Item No. **Report of the Head of Planning, Transportation and Regeneration**

Address 51 ICKENHAM ROAD RUISLIP

Development: First floor rear extension with habitable roofspace to include 2 x rear rooflights.

LBH Ref Nos: **24650/APP/2021/59**

Drawing Content:
Proposed First Floor Plan

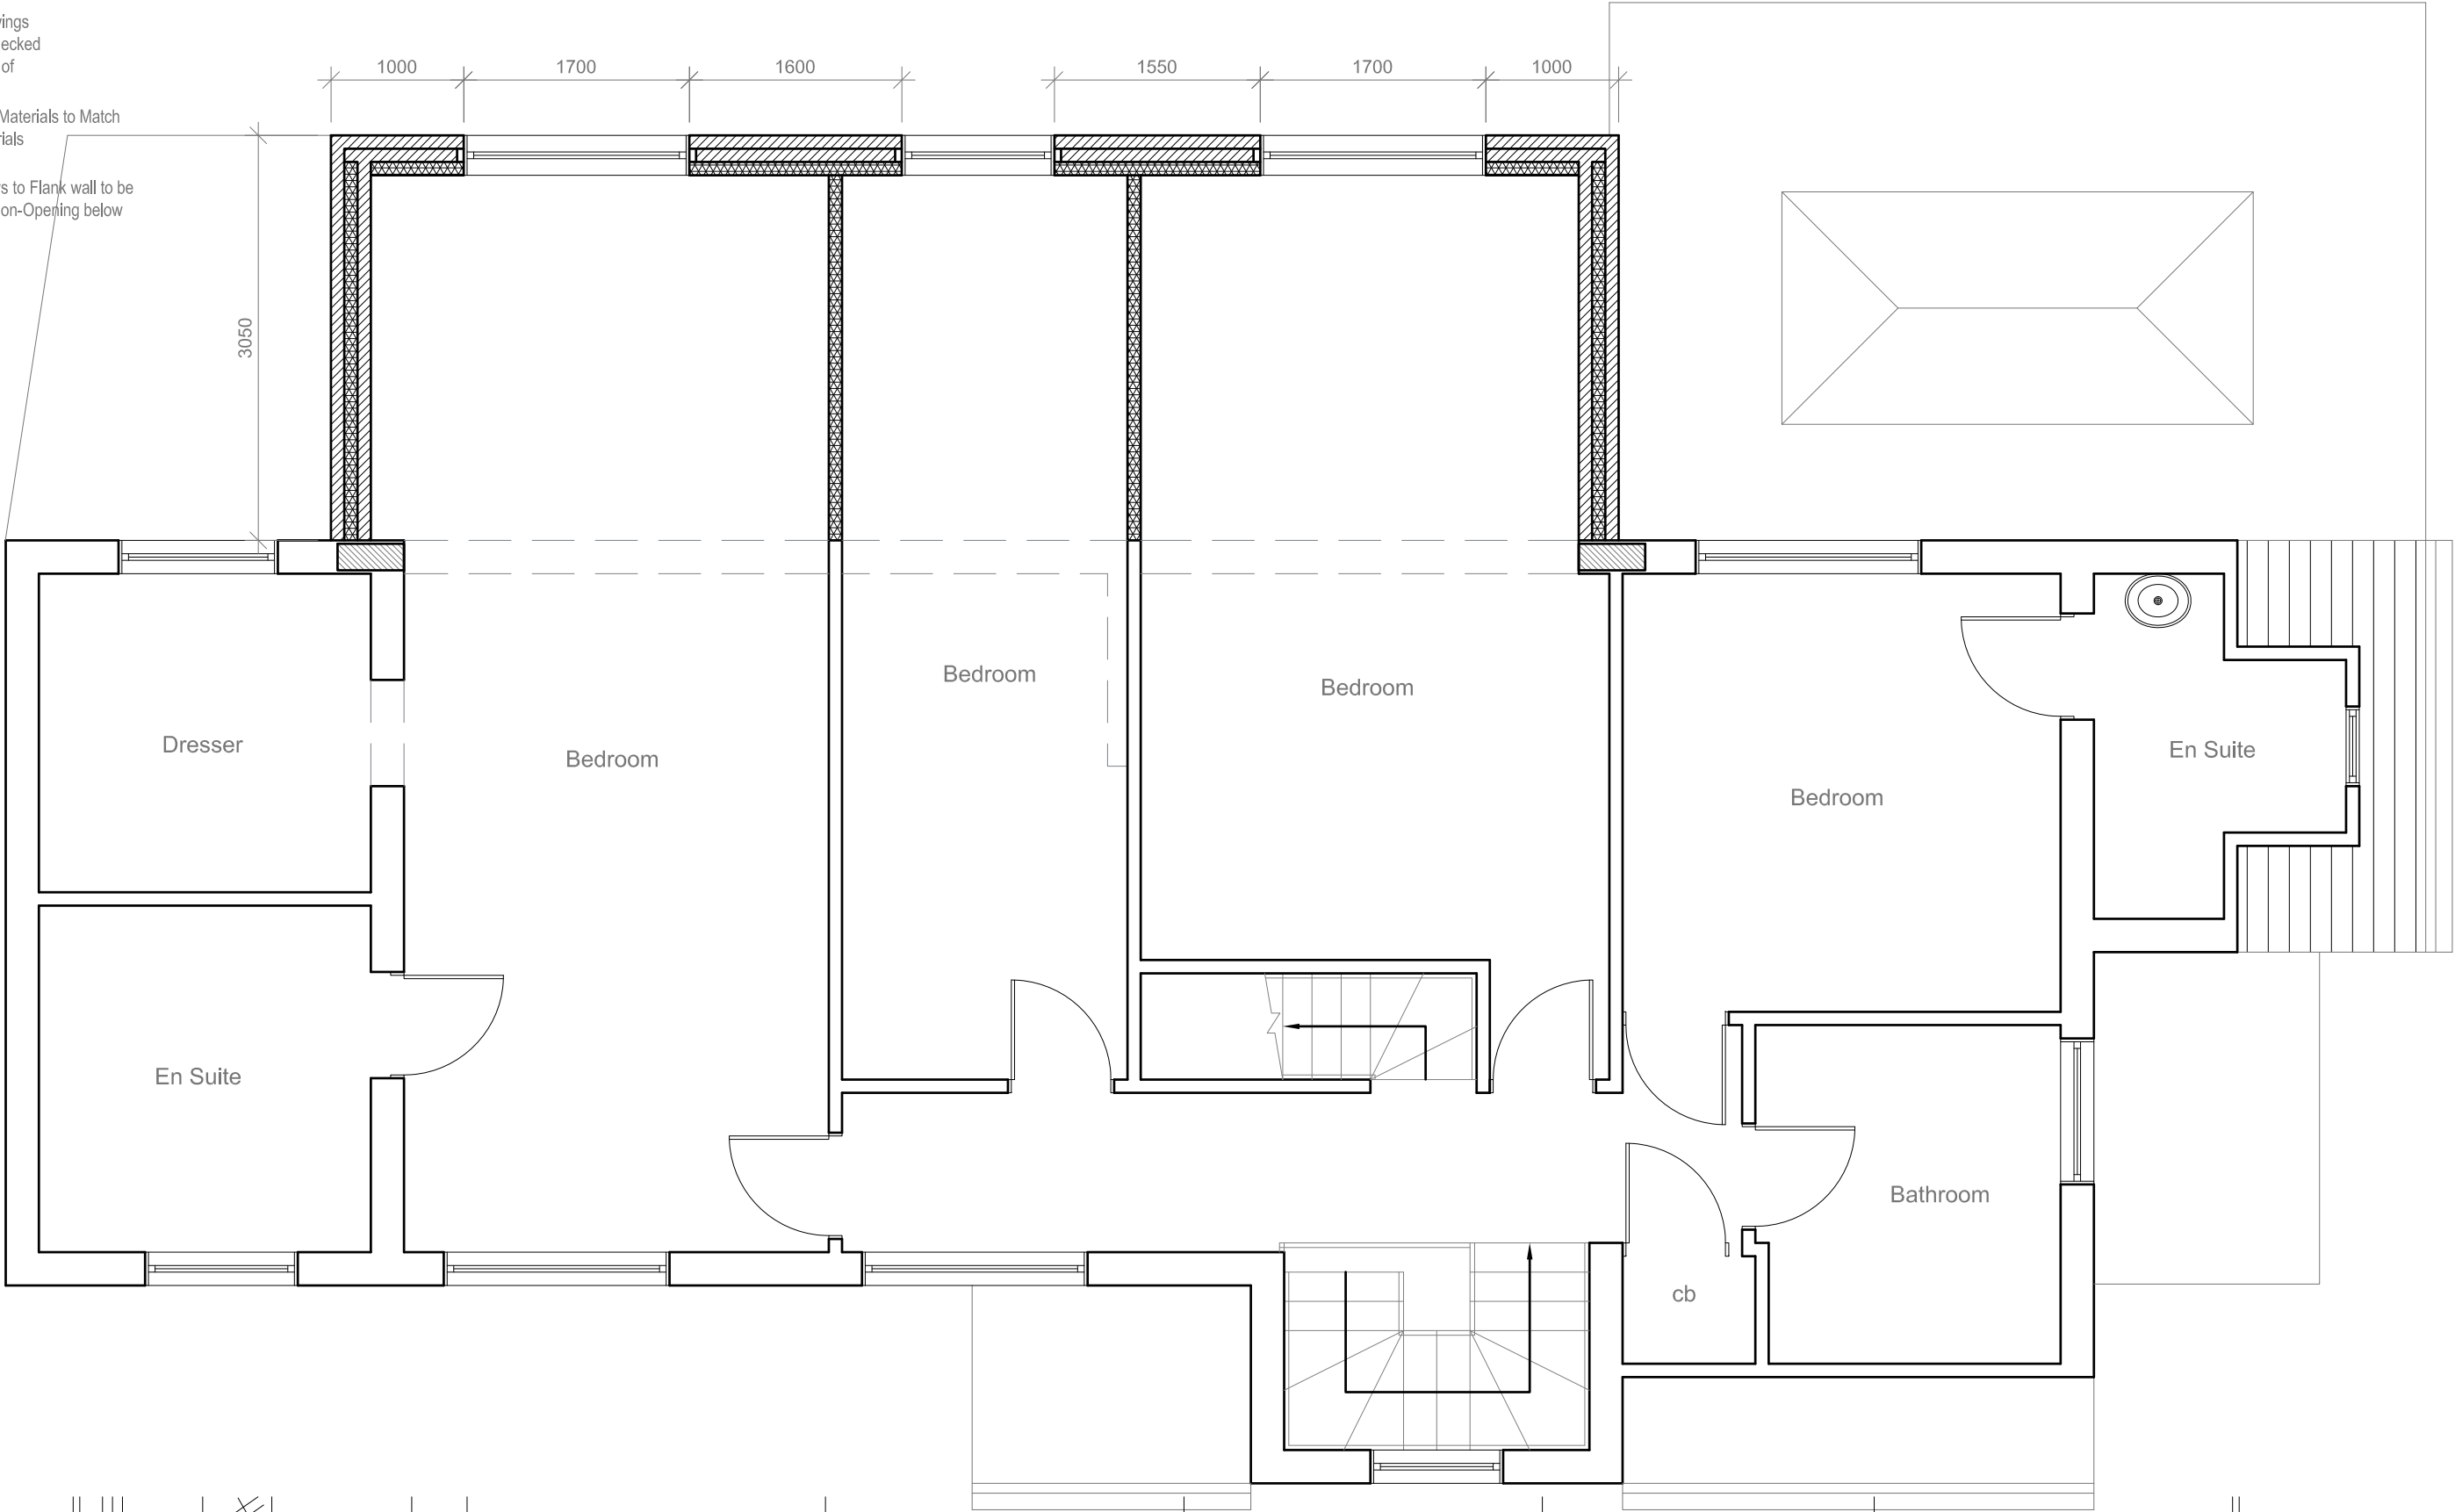
The submitted plans indicate that the proposed first floor extension measures 3 m in depth and is set away from the side boundaries by approximately 3 m to East with no. 49 and 9.5 m to the West with no. 53. The proposed extensions would not compromise a 45 degree line of sight from the neighbouring properties and given the degree of separation between the application site and adjacent dwellings the proposals would not result in an unacceptable loss of light or outlook to the occupants of those properties. The nearest property to the rear is no. 50 Kingsend situated approximately 33.5 m away. The principle windows for the proposed extensions would face front and rear and would not result in any additional overlooking or loss of privacy to that already existing. It is therefore considered that the proposed development would not constitute an un-neighbourly form of development.

Drawing Content:
Proposed Elevations

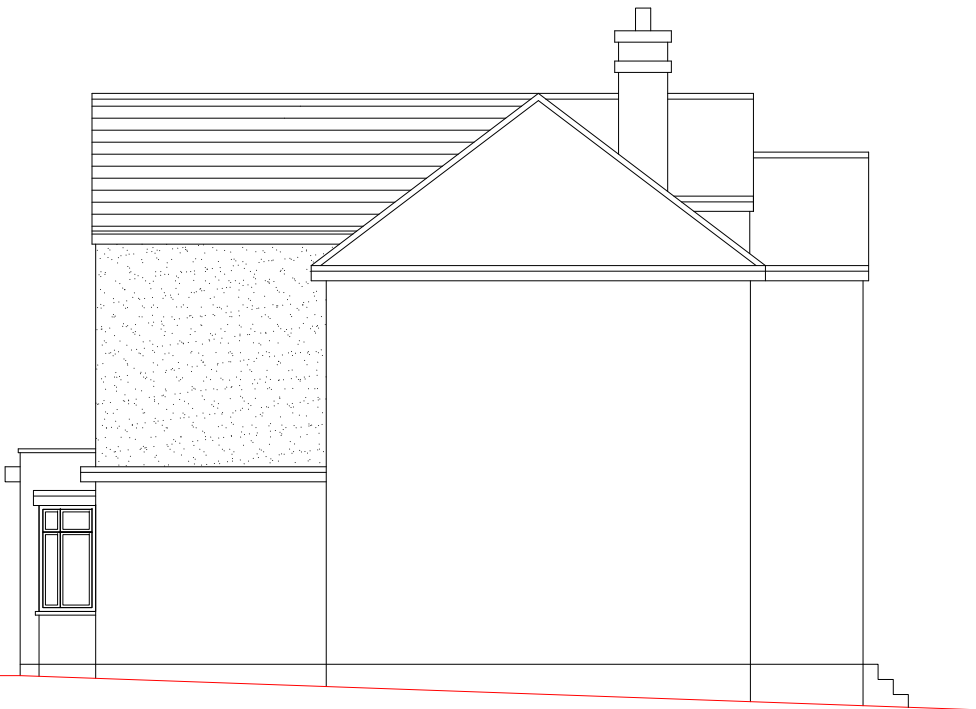
The principle of the proposed development would be similar to the allowed scheme, erecting a substantial built mass to the rear of the existing property. The proposed development however would include an incongruous mansard roof form between the existing gables. The proposal would significantly increase the bulk of the roof creating a boxy form. The mansard style of the roof would fail to relate to the original form of the existing property and mansard roofs are not a characteristic feature of the conservation area. The addition would disproportionately extend the existing property. The roof addition would have a similar impact to a standard box dormer extension. Such additions are not deemed acceptable in a conservation area. The proposed development would be

The current proposal is of the same width and depth and incorporates the same gable features, however the crown roof above is extended with a minimal pitch, forming a mansard style, which would fail to relate to the original form of the existing property. The Conservation Officer has raised strong concerns over the proposal advising the addition disproportionately extends the property and would be inappropriate de elopement within the conservation area. Whilst noting the Inspectors previous comments with regard to the visibility from the wider streetscene, whilst the public views of the site would be limited, views of the development would be highly visible from neighbouring properties. Private views from rear gardens and within the site itself also form part of how the heritage asset is experienced therefore it should not lessen the requirement to preserve or enhance the character and appearance of the conservation area. Therefore in terms of appearance the proposed mansard roof form would fail to respect the character and appearance of the existing property and the wider Conservation Area and is considered unacceptable. As such the proposal fails to comply with the requirements of Policies DMHB 4, DMHB 11, DMHB12 and DMHD 1 of the Local Plan: Part Two - Development Management Policies

The proposed development, by reason of its size, scale, bulk and design, including the mansard roof detail, represents an unduly intrusive and incongruous form of development, which would fail to harmonise with the character and appearance of the original dwelling and would fail to either preserve or enhance the character or appearance of the surrounding Ruislip Village Conservation Area. The proposal is therefore contrary to Policies DMHB 4, DMHB 11, DMHB12 and DMHD 1 of the Local Plan: Part Two - Development Management Policies (2020), Policy HC1 of the London Plan (2021) and the NPPF (2019).
